Addendum #5

**The Parkside Neighborhood Center
and Affordable Housing
Mellen & Grant Streets,
Portland, Maine 04101**

May 3, 2004

HVAC1.4

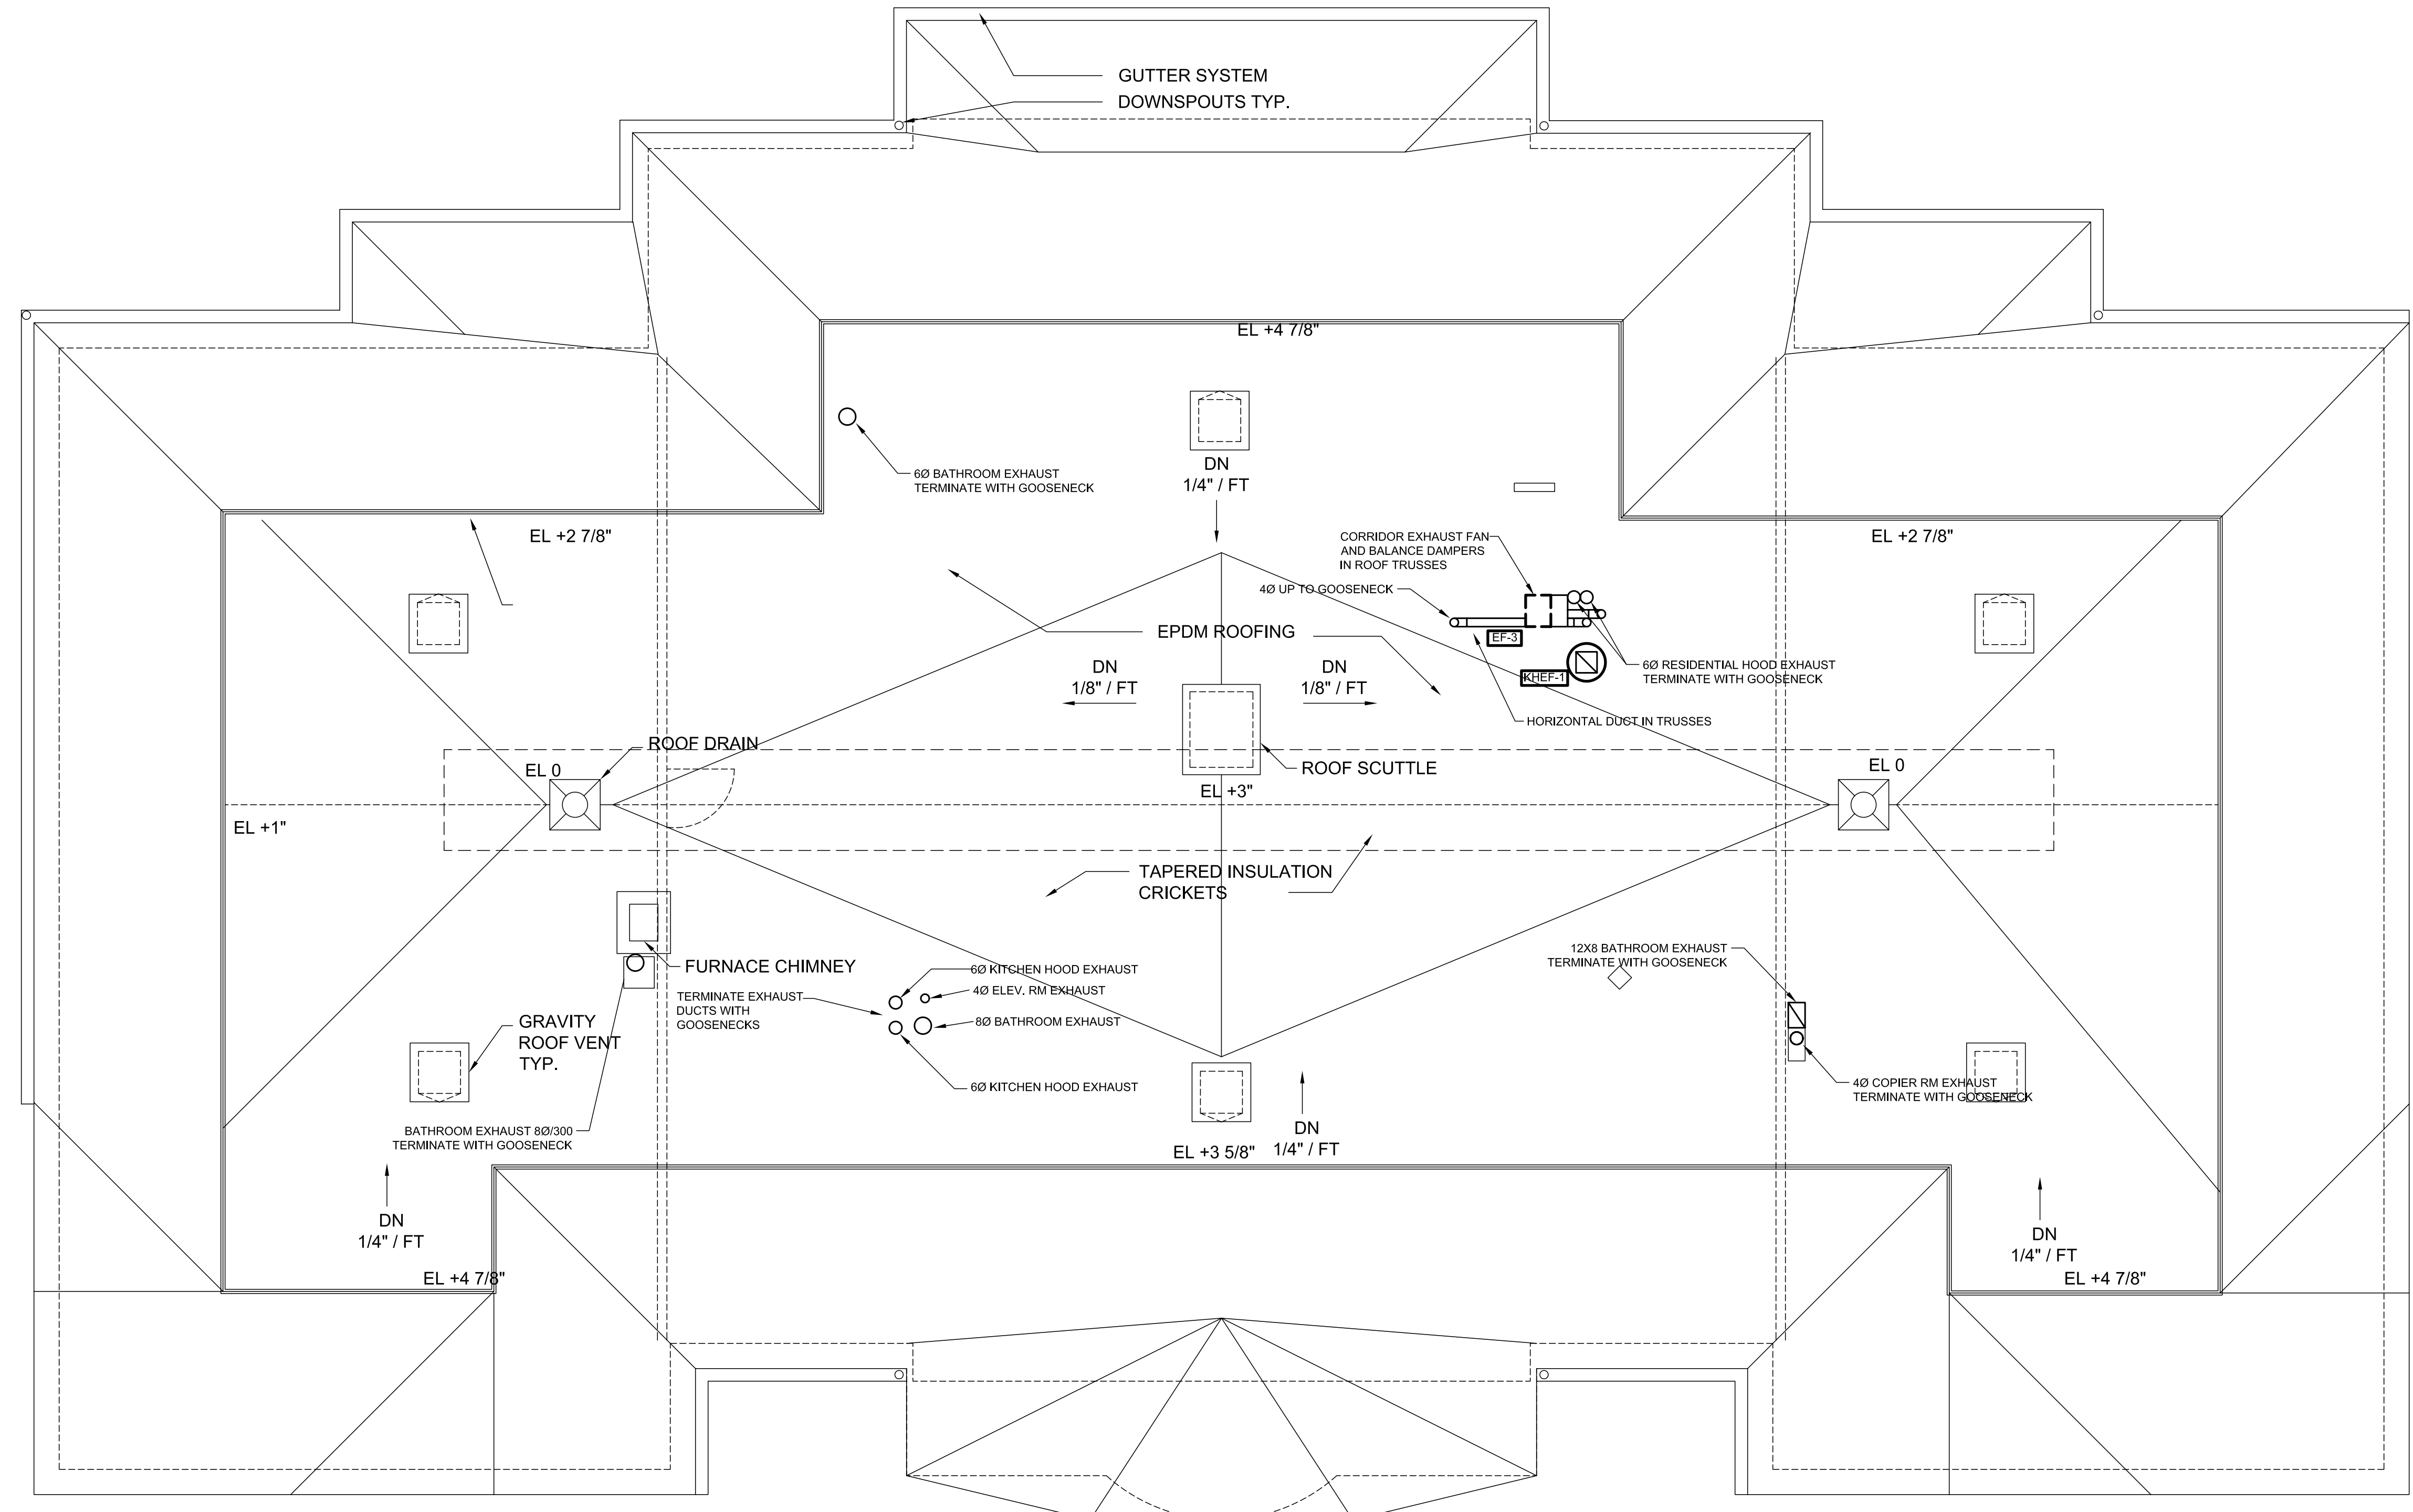
1. Add Mechanical General Note 10:
Provide additional fire damper and access door:
 - a. At ducts penetrating walls of shafts both at entrance in Basement and exit in Attic, including residential kitchen hood ducts. Note: Do not install fire damper in commercial hood exhaust duct in Building A.
 - b. At ducts penetrating 3rd floor ceiling-attic "floor". Examples are duct risers into attic from 3rd floor bathroom exhaust fans tagged EF-1. Penetrations are shown on Drawing HVAC1.4 also.
2. Add Mechanical General Note 11:

HVAC2.3

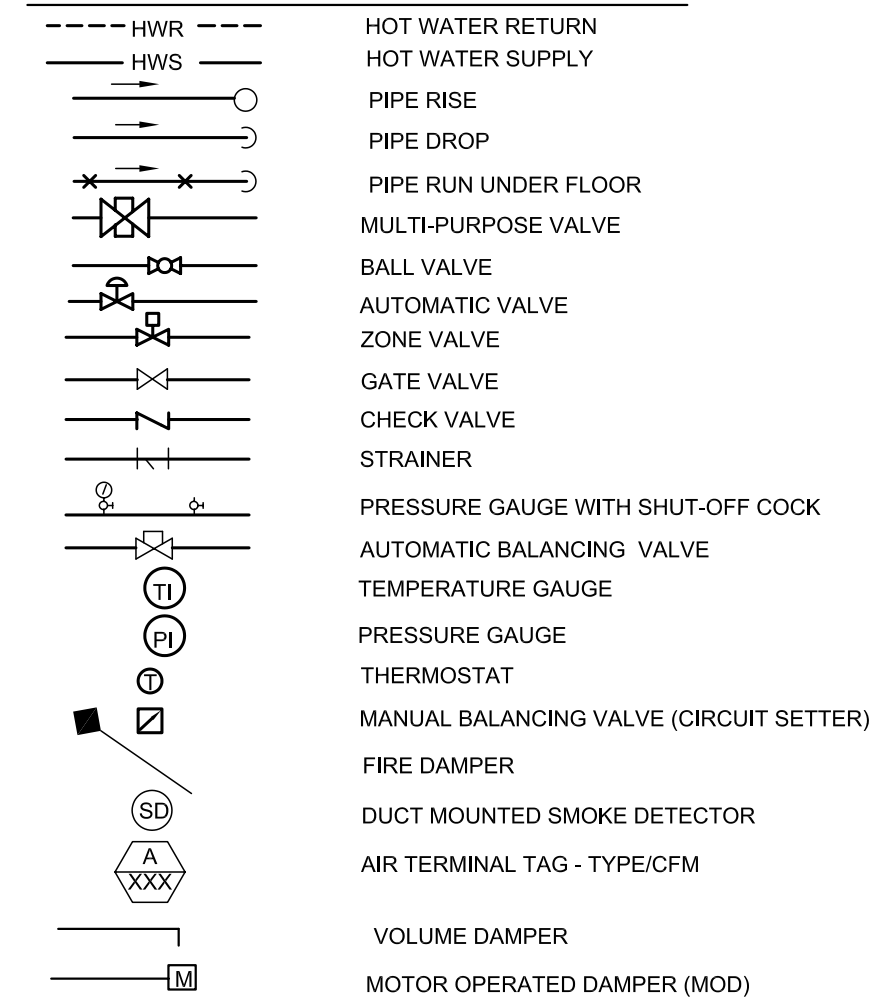
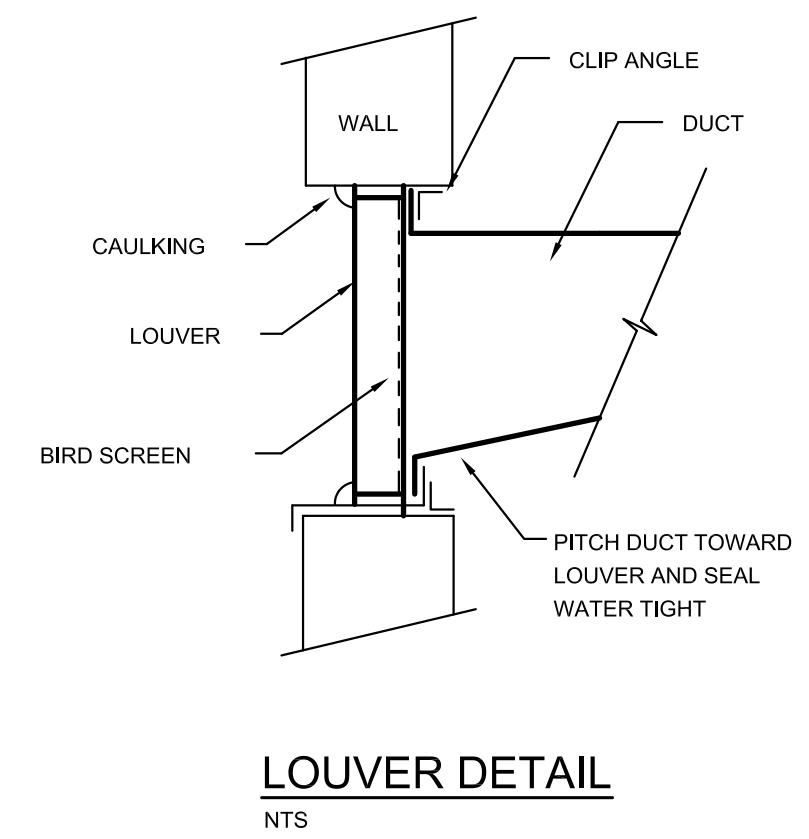
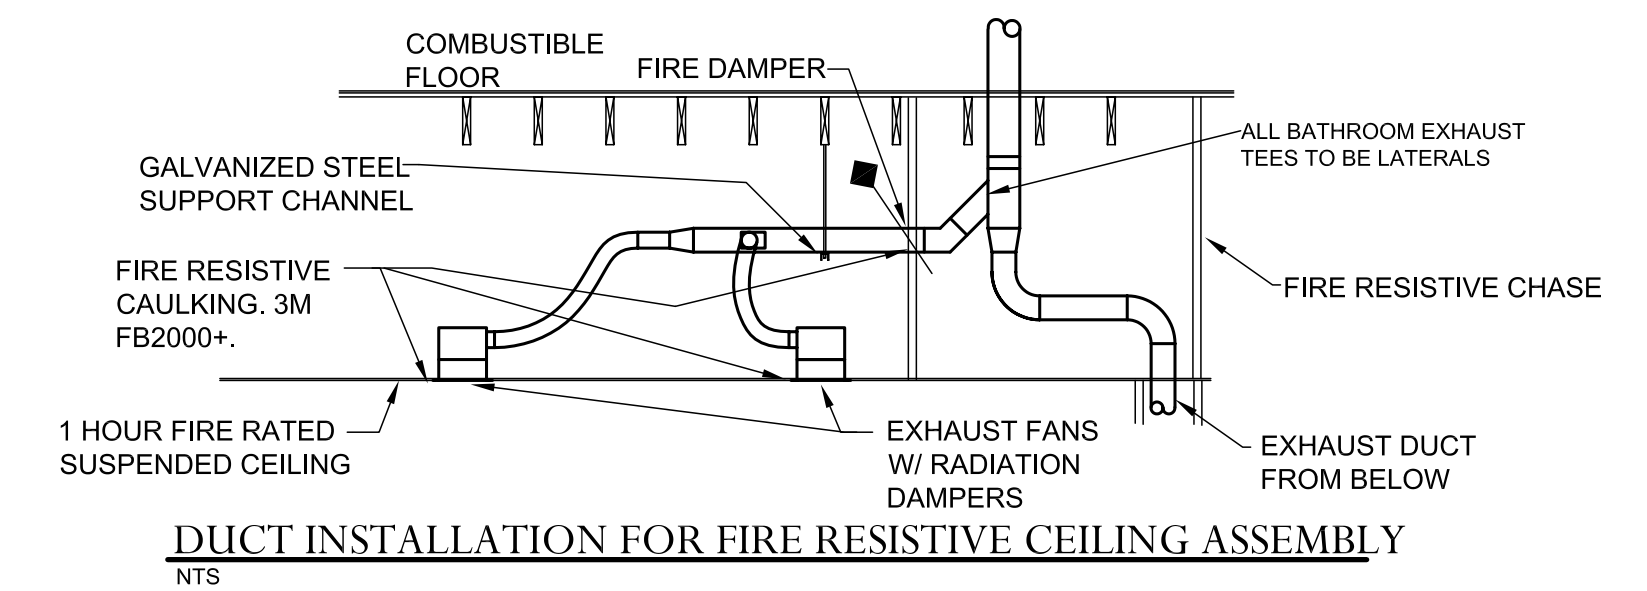
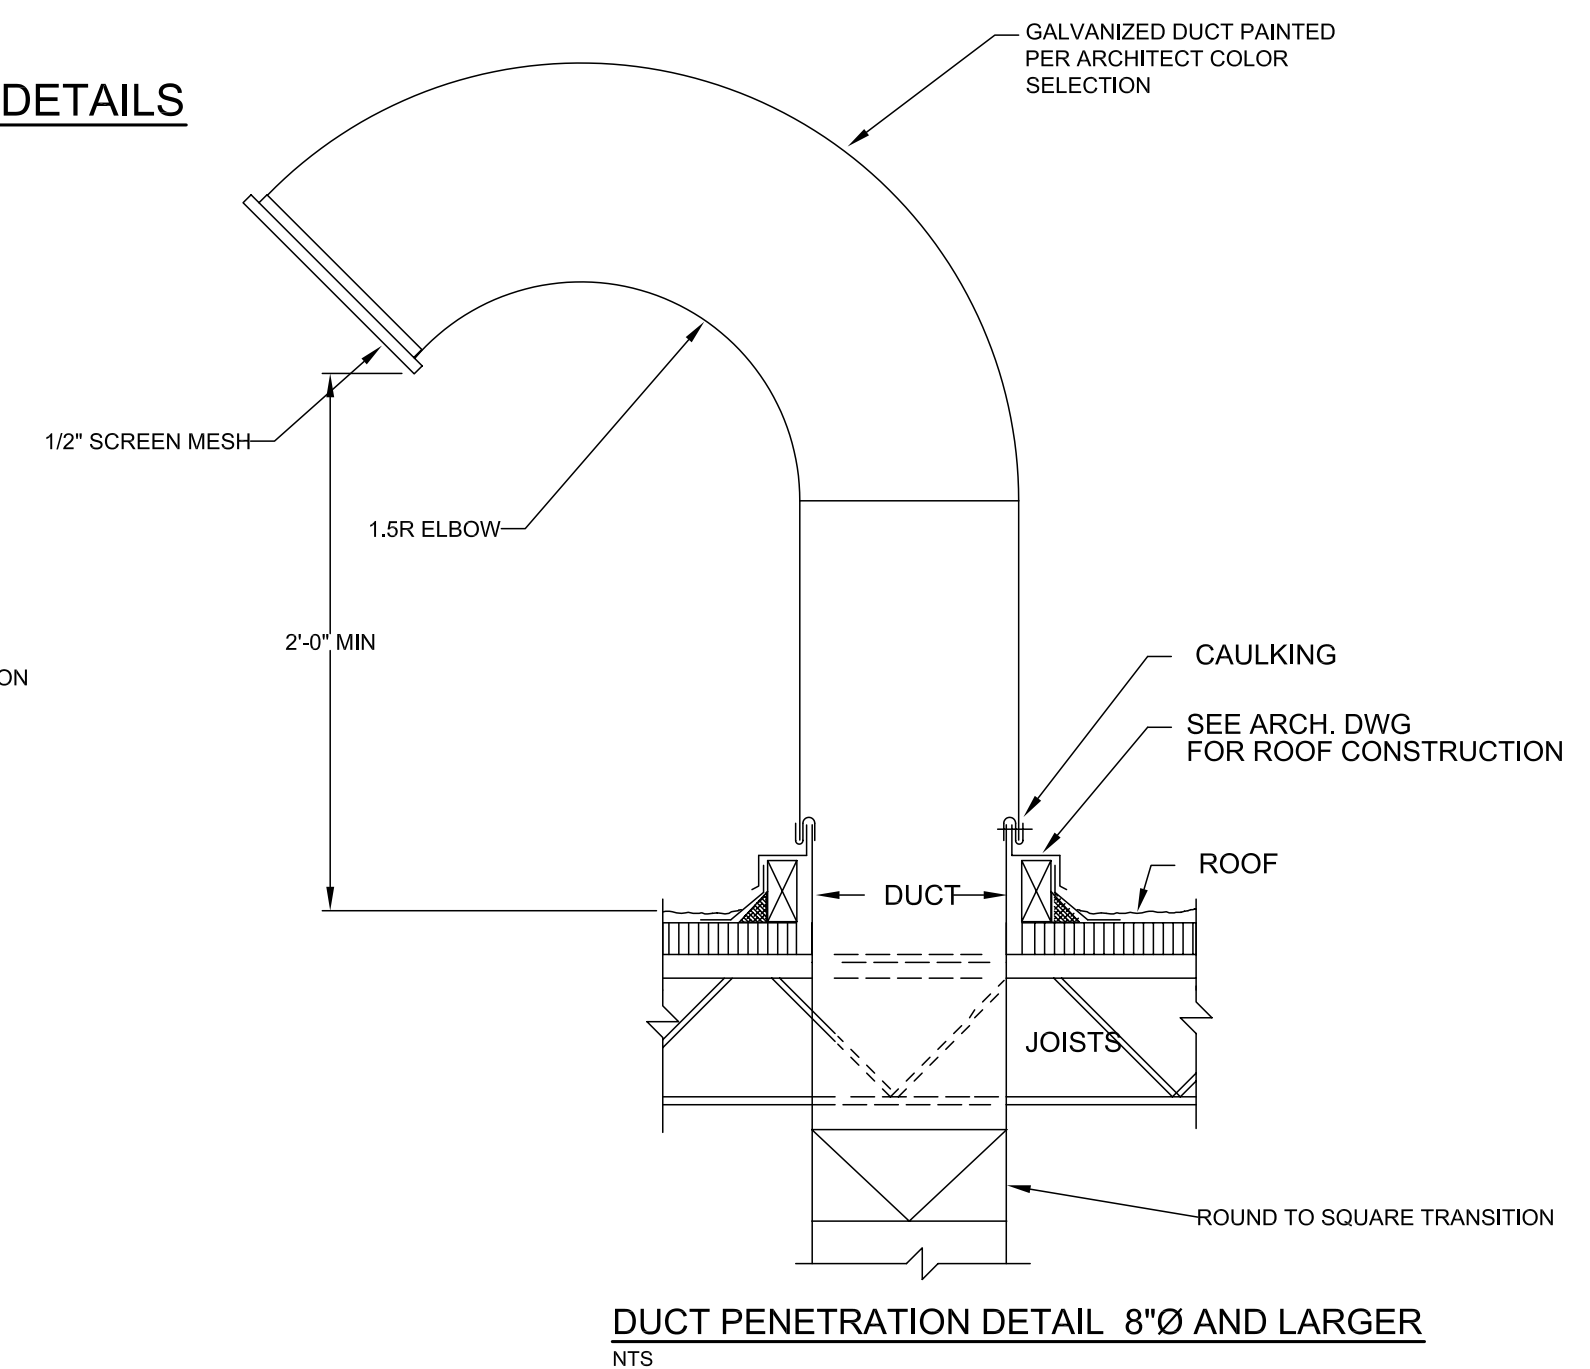
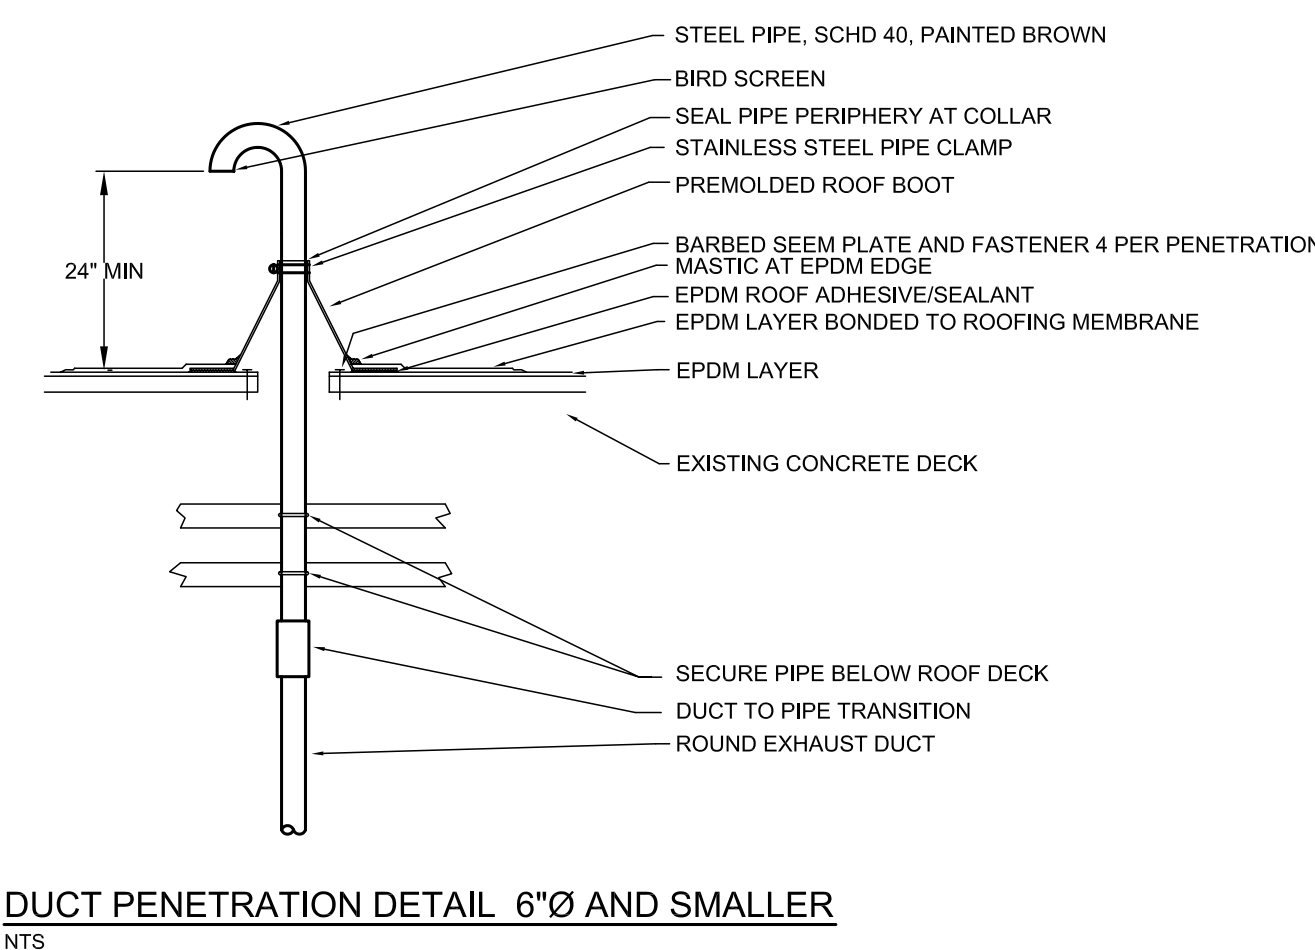
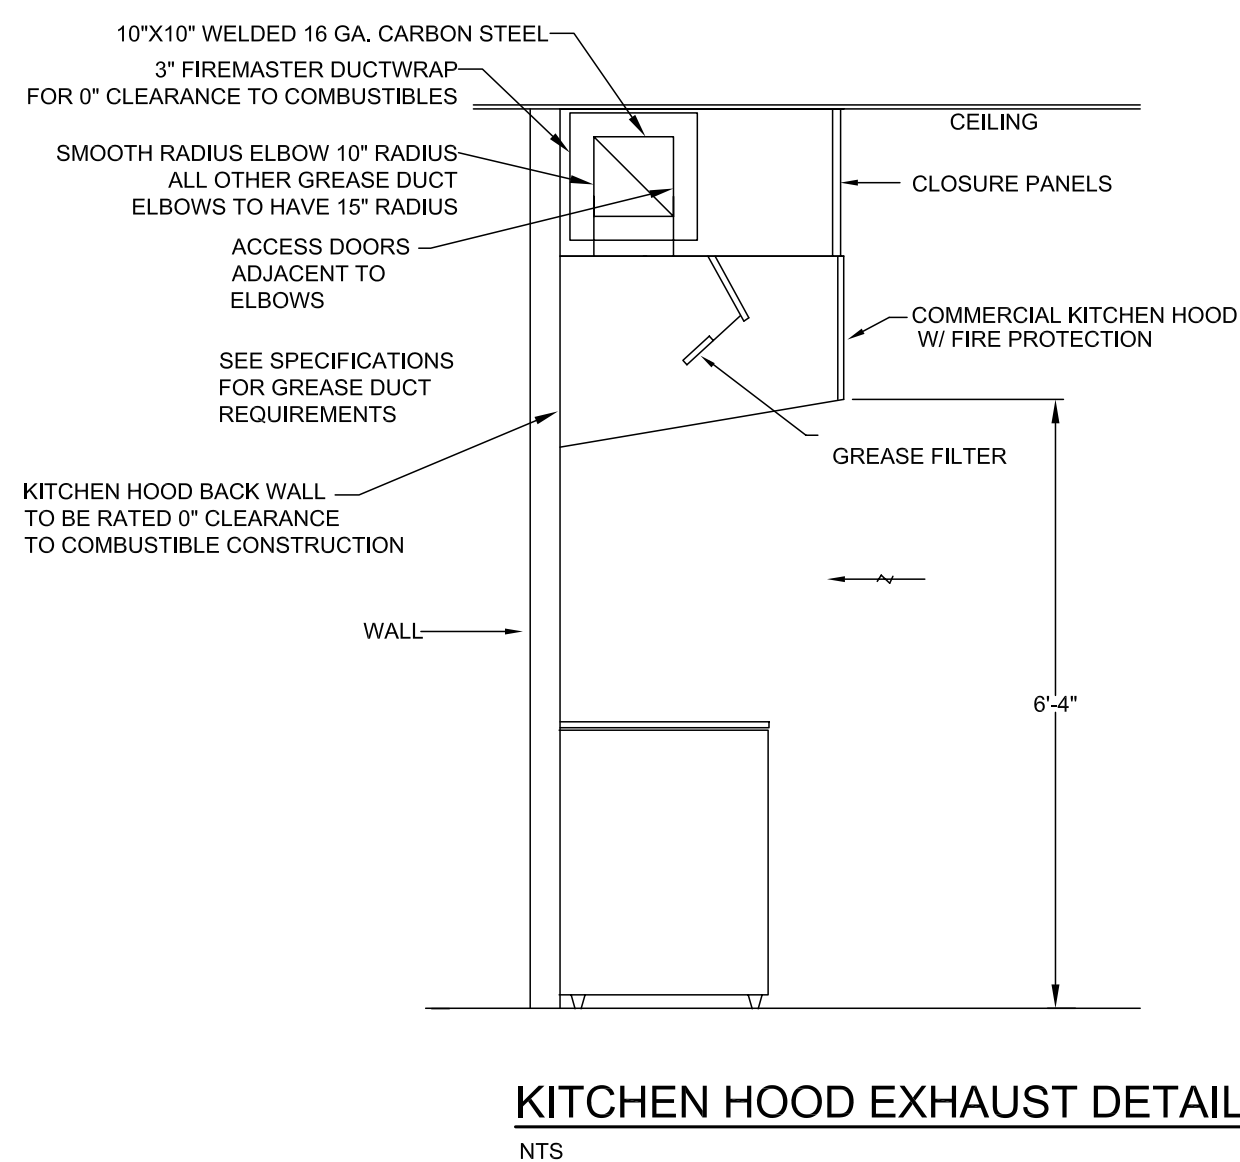
4-55 A/B HVAC2.3 ADD to the Mechanical General Notes the following:

Provide 4" Schedule 40 PVC radon exhaust from slab penetration up boiler vent shaft, through attic space and roof. Terminate with 90 degree gooseneck similar to "Duct Penetration Detail 6" diameter and Smaller" shown on Drawing HVAC 2.3 (Note: delete words, "existing concrete deck"). Support PVC pipe in shaft. Allow space for future radon exhaust fan in vertical rise between attic "floor" and roof deck.
